Please upload the below to the above application. WSCC comments

This application is for the erection of a 19m monopole with wraparound cabinet at base and three additional cabinets at ground level. The site is located on Victoria Drive, a C-classified road subject to a speed limit of 30mph.

MAX CONFIGURATION SITE PLAN

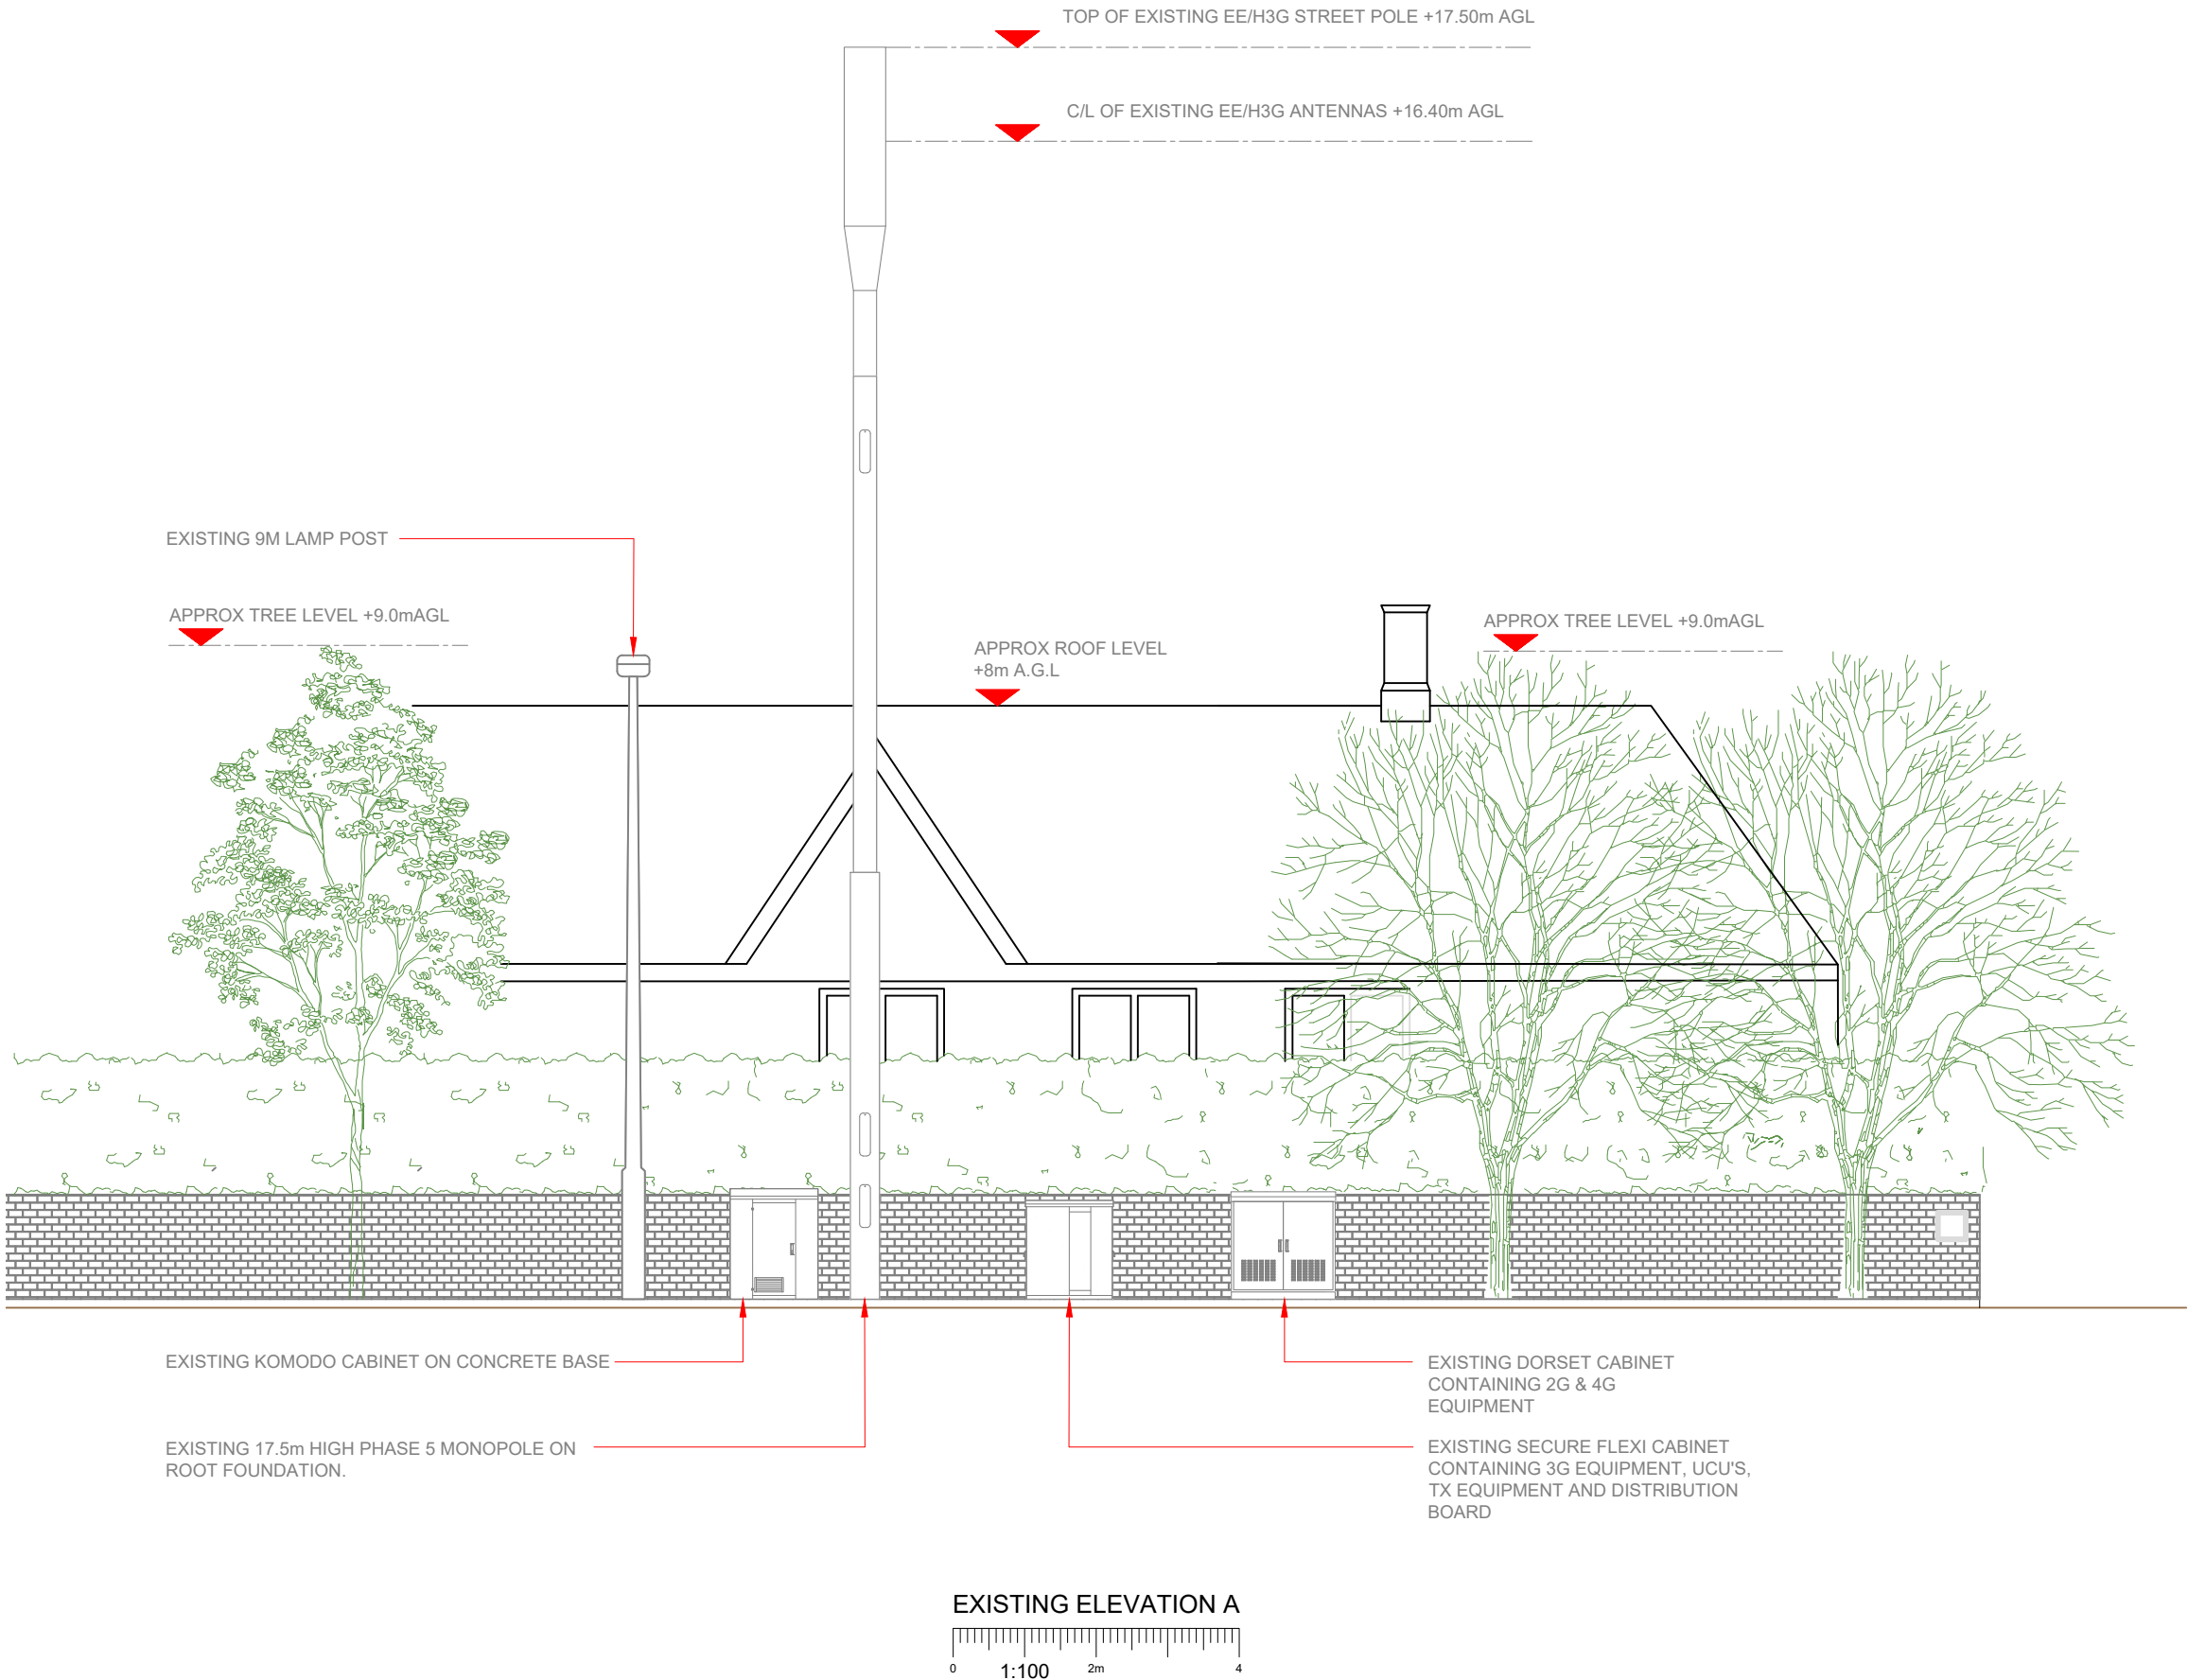
Having inspected these plans and can see that the proposed pole and cabinets will be moved slightly further north east than currently positioned. On the basis that the existing pole and cabinets will be removed, and that the proposed infrastructure will retain greater than 1.5m minimum footway width, I am satisfied that there would be no obstruction to pedestrians in this location and no highway safety concerns would be raised.

The proposed cabinets and pole will be located on the footway of Victoria Drive, within the public highway. The LHA request clarification from the applicant whether the proposed pole and cabinets will be a replacement of existing pole and cabinets, or in addition to these? A detailed site plan is requested to demonstrate the proposal in relation to the existing footway and existing street furniture, for example, trees and lighting pole to ensure that sufficient footway width remains. Inclusive mobility sets out a minimum footway width of 1.5m.

In terms of the detailed site plan request, I'd have thought drawing 215 shows this? It's drawn to scale and shows the area around the application site.
